Please ask for: Ms Iqraa Malik
Email: iqraa.malik@terraquest.co.uk
Telephone: 01212341390
Our Ref: R/67/21/HH
Your Ref:
Date: 1st April 2021

Application for Planning Permission for Works or Extension to a Dwelling

Development: Two storey extension to rear of property
Location: 57 Mill Lane Rustington BN16 3JP

Site Block Plan 1:500

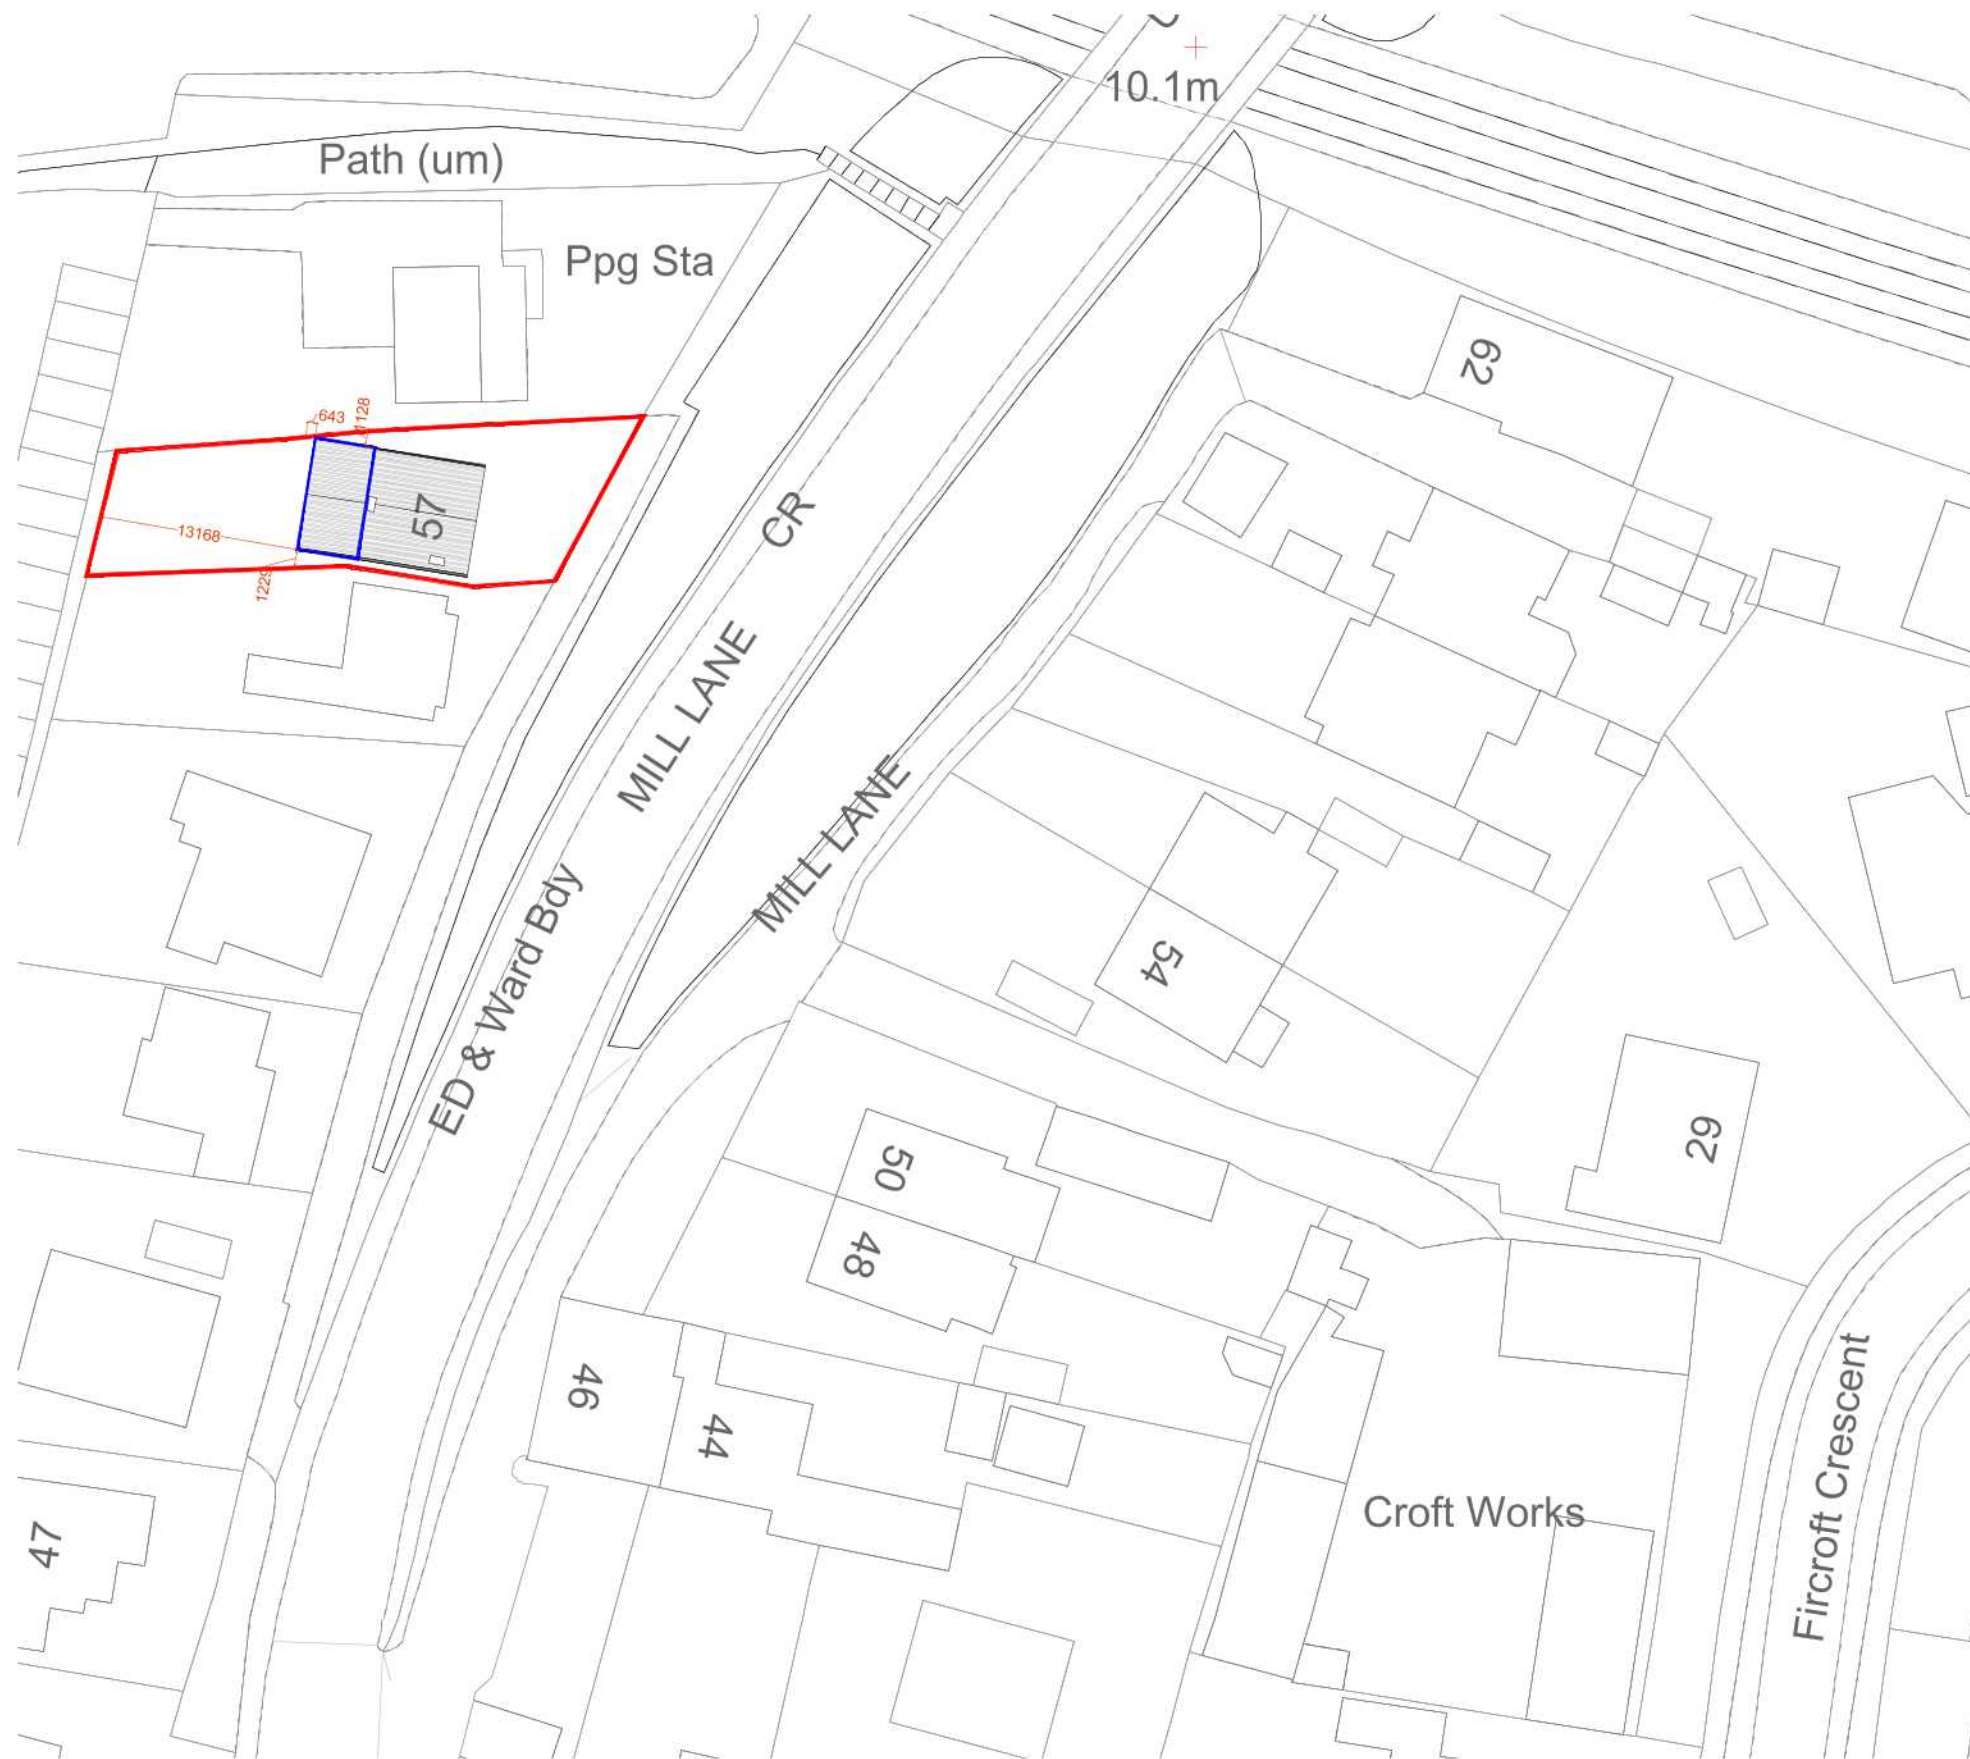
Block Plan

You are required to have dimensions from the proposed extension(s) to all site boundaries. Please amend.
